Ref: C2911_CS

Re: Barnfield House, Fontwell – LLFA Comments designers' response

Application reference: WA/86/25/DOC

We write in relation to the recently received comments from the LLFA in relation to the above scheme and specifically Condition 9 – As built drawings of surface water drainage scheme.

Section Inspection - 16/07/2025 - S18X

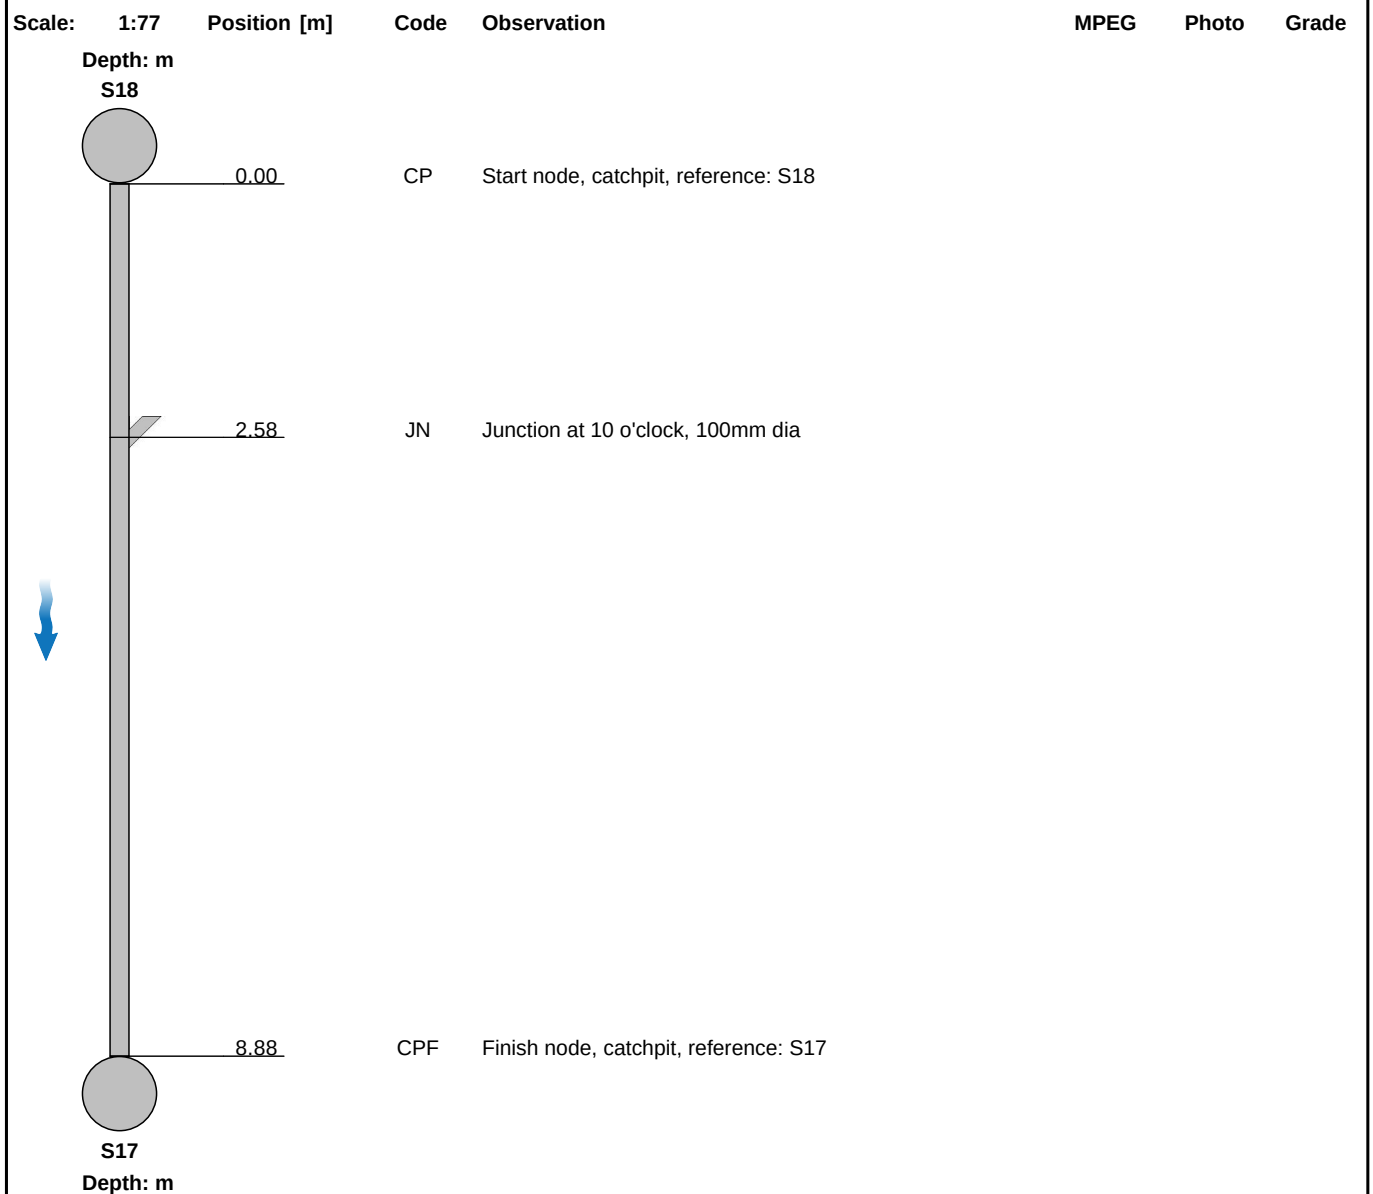
3 - Evidence of all flow control chambers – product, orifice diameter, IL plus photos of internal chamber as installed. There is no photograph of S14 installed. The orifice diameters for the flow control chamber is not evidenced for S14 or S18.

Photographs have now been provided in the updated report of the orifice chambers. The product is confirmed as the SEL 500 diameter flow control chamber and the invert levels as designed.
